CITY OF PORTLAND
DEPARTMENT OF PLANNING & URBAN DEVELOPMENT
 389 Congress Street
 Portland, Maine 04101

Inspection Violations

Owner/Manager ACETO CHARLES D		Inspector Suzanne Hunt	Inspection Date 5/4/2009
Location 744 BRIGHTON AVE	CBL 259 B060001	Status Re-Inspect 30 Days	Inspection Type Building Permit-Legalize Nonconf

1ST & 2ND FLOOR
UNITS
1/8" SCALE

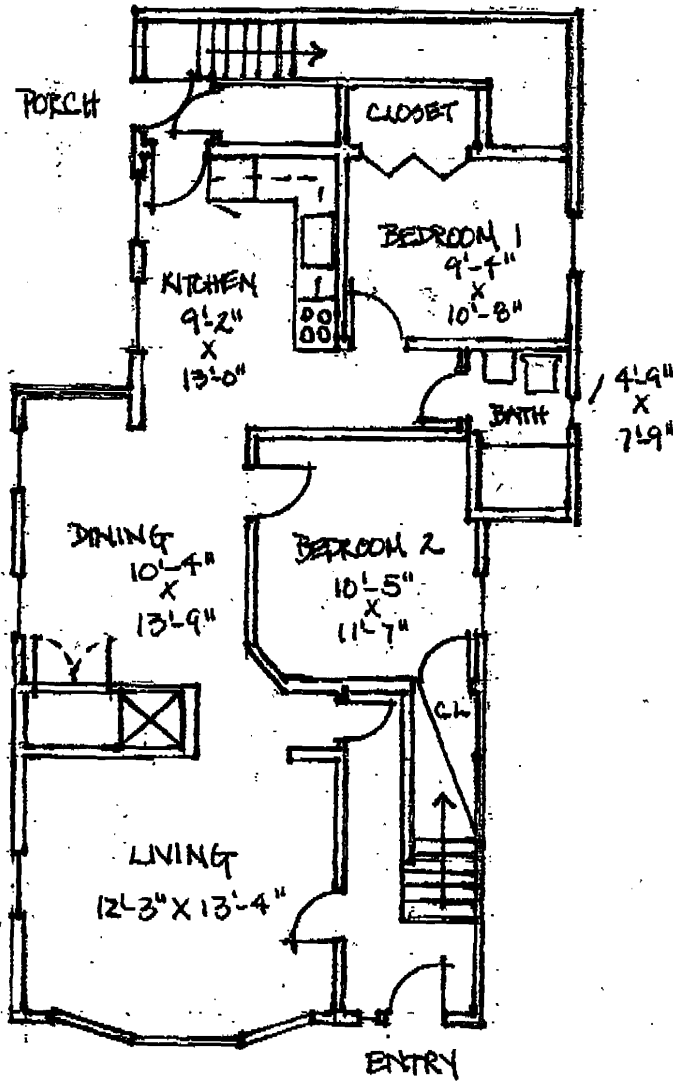
Code	Int/Ext	Floor	Unit No.	Area	Compliance Date
1) 6-116.(b)	Interior				06/03/2009
Violation: Egress					
Notes: Stairway from 2nd floor to 3rd floor (back of building) is required to have a continuous handrail. height of handrail measured shall be uniform , not less than 34 or more than 38 inches. With graspable rail per code. IBC 2003 1009.11.1

5) 6-116.(e)	Interior				06/03/2009
Violation: Fire Protection					
Notes: furnace in basement requires sprinkler head					
Comments: continuous rail needed floor 2 to 3 back stair case , pressure relief discharge pipe is currently incorrect, paper backing on insulation (basement) must be removed or covered, sprinkler over furnace required
